Response to Planning Application

From: Arun District Council Greenspace

Application ref: WA/106/20/DOC

Description: Approval of details reserved by condition imposed under ref WA/22/15/OUT relating to Condition Nos 6 - materials & finishes, 10 - hard & soft landscaping, 11(a) - protection of retained trees, 12 - surface water drainage, 14 - maintenance & managements of SuDs, 15 - foul drainage and 20(d) - forecourt layout, drainage, position & intensity of lighting fitments.

Detailed Planting Plan - Ornamental Planting GTR Factory, Arundel Road, Fontwell, West Sussex

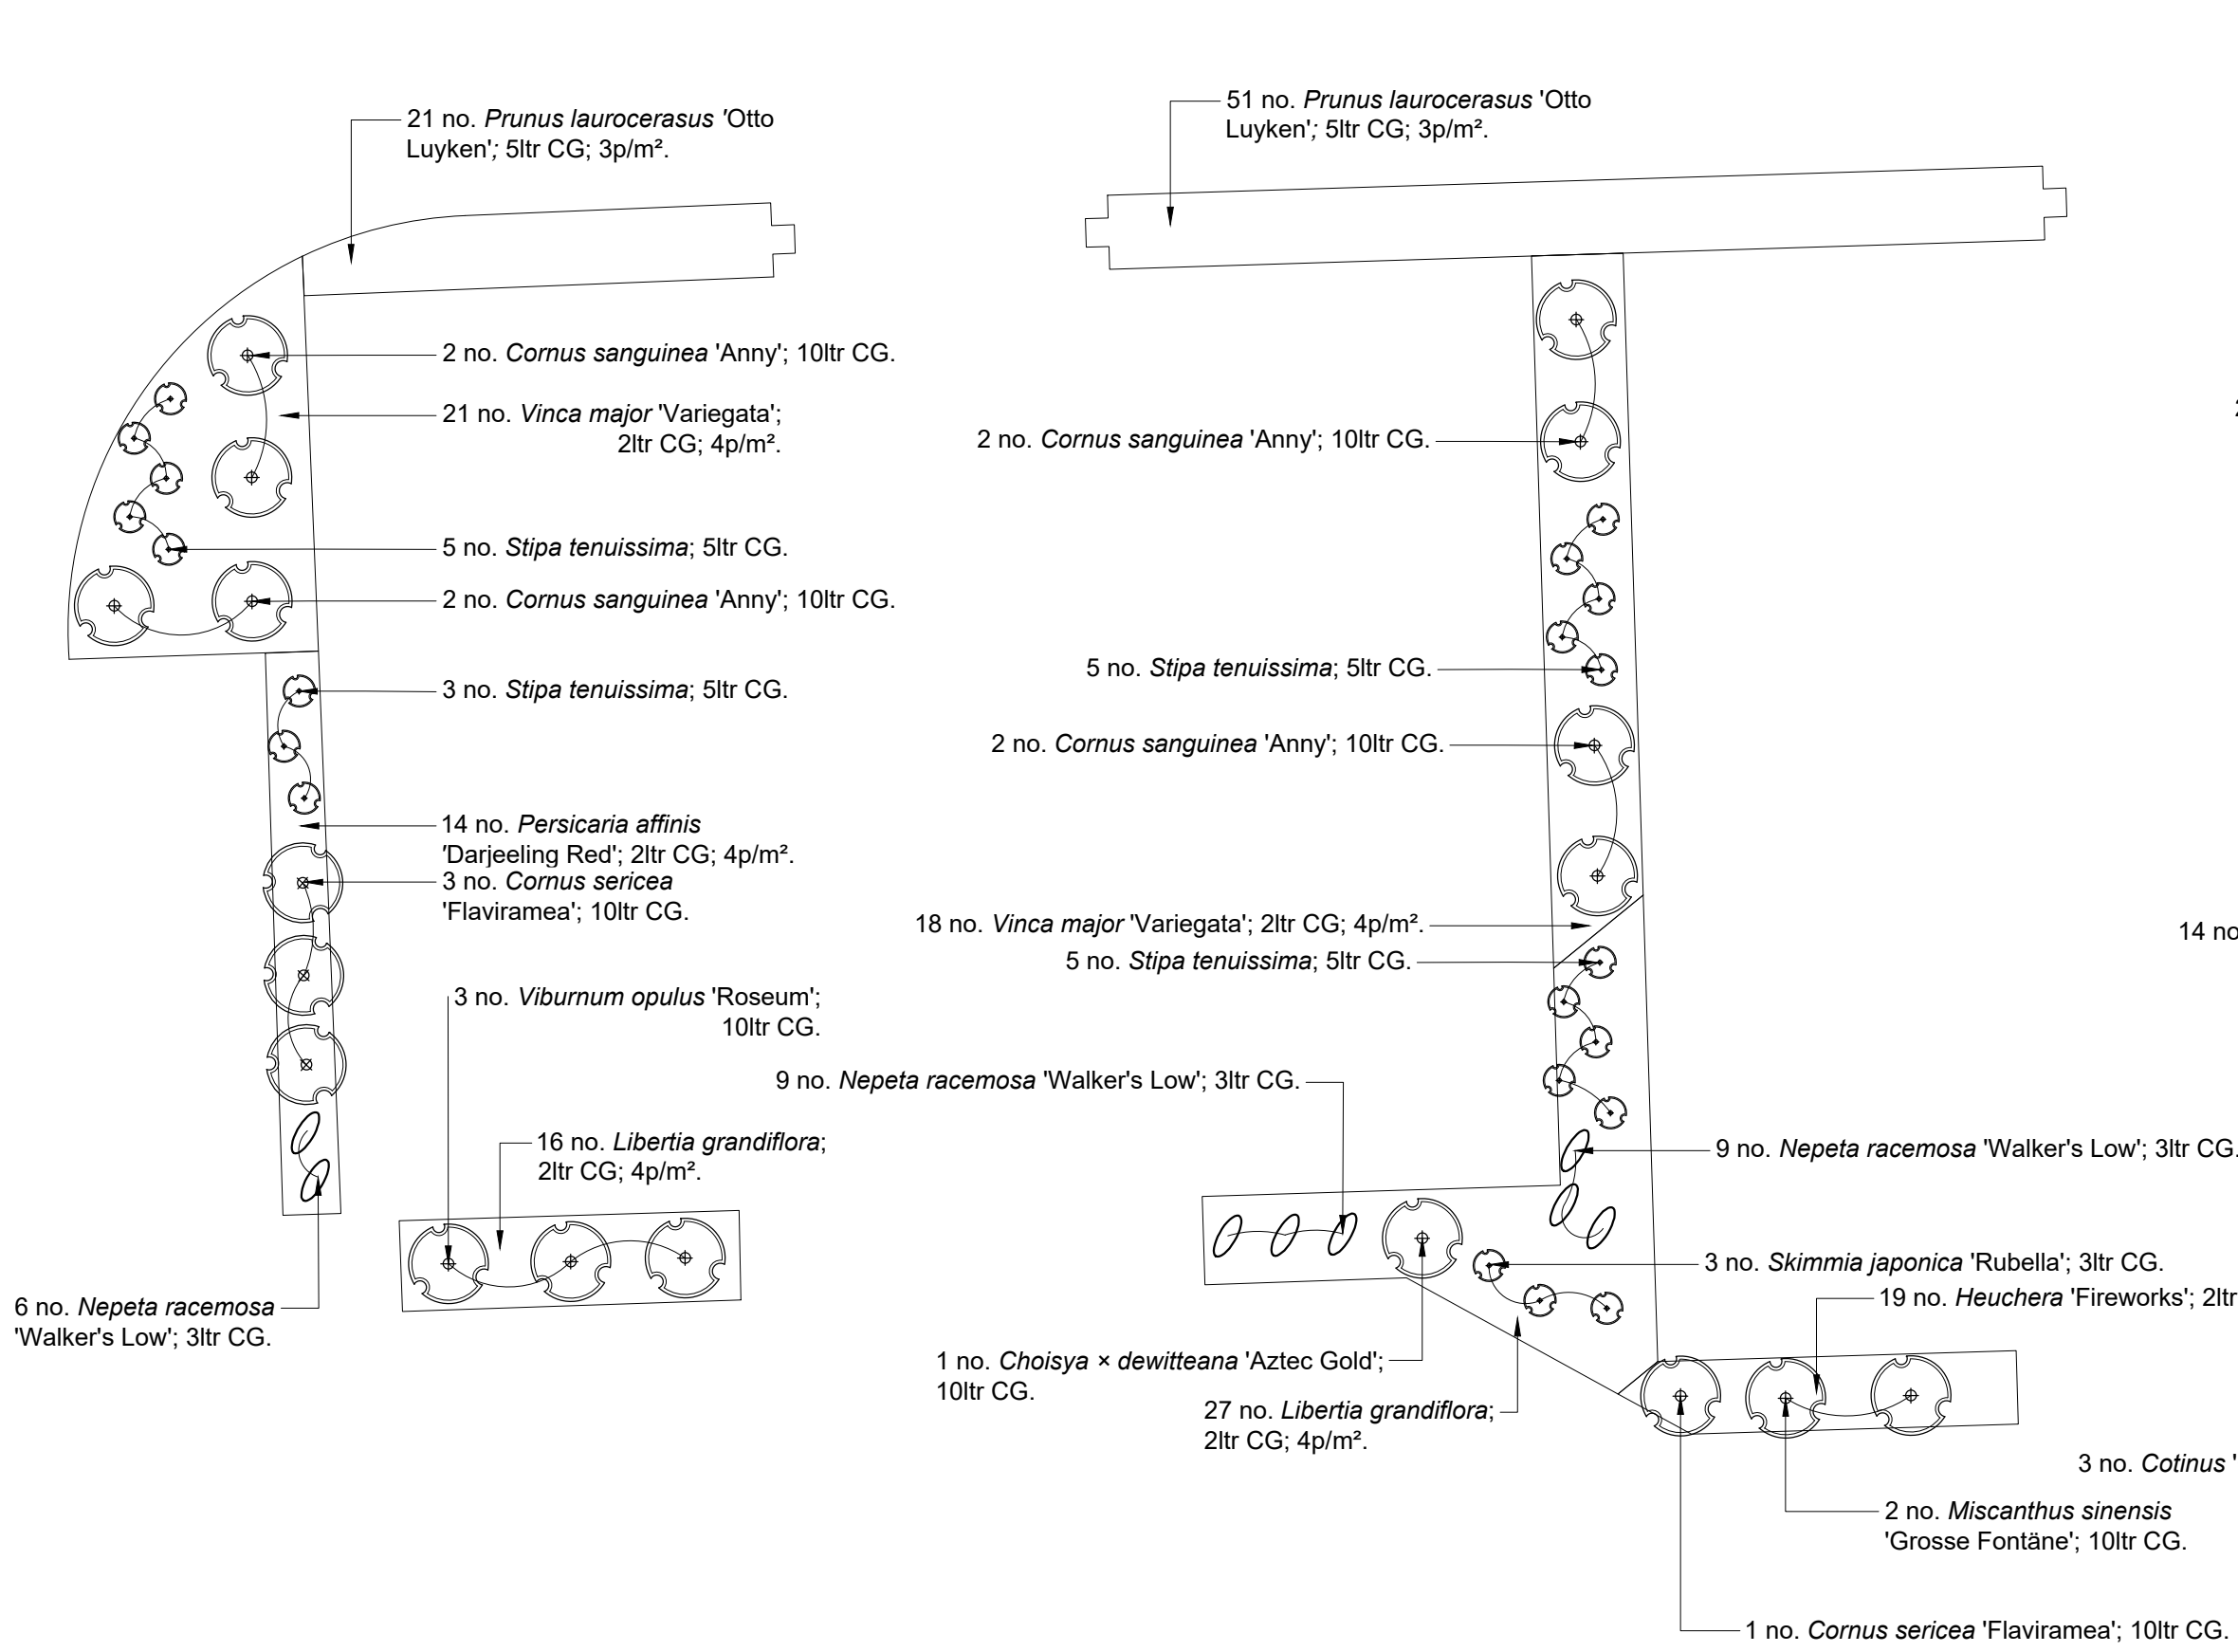
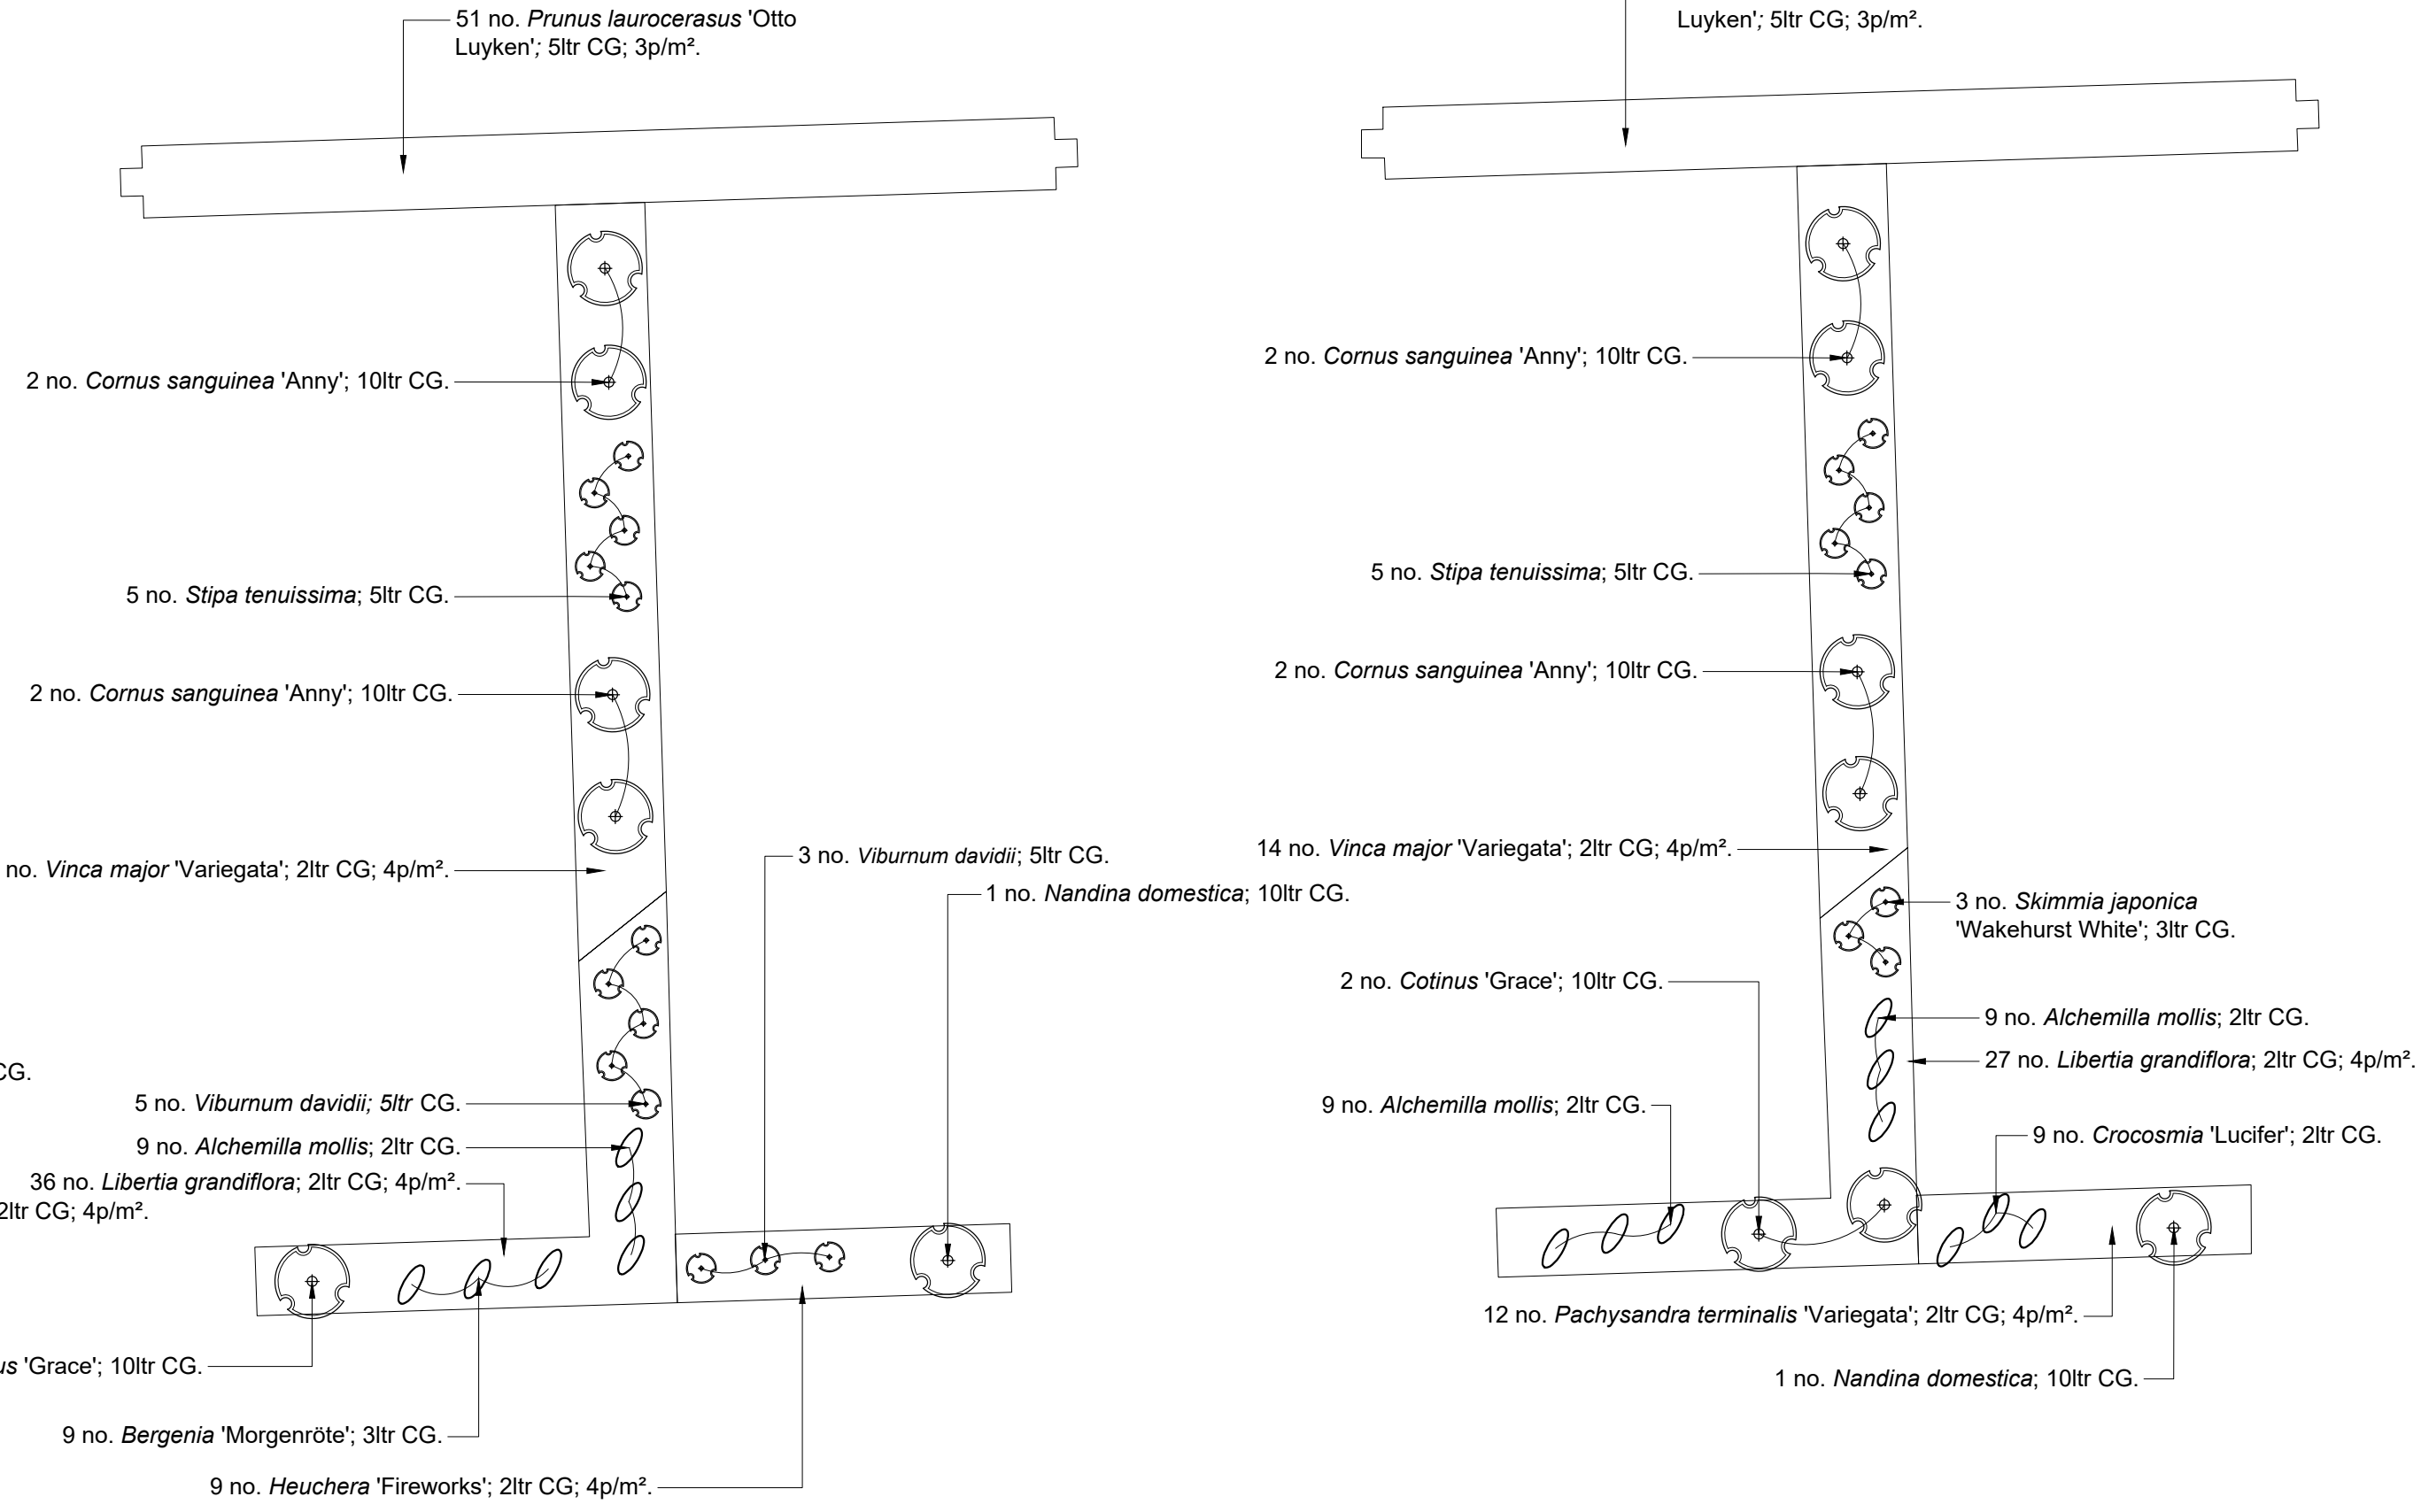
I can confirm that the proposals detail a scheme which would be suitable for location and fitting for this setting. The detail has included a good element of native mixed tree and hedge planting mixes which will aid in biodiversity gain and habitat formation. The scheme has also considered an ornamental element to the planting which would be suitable for the building, carparking and communal surrounds.
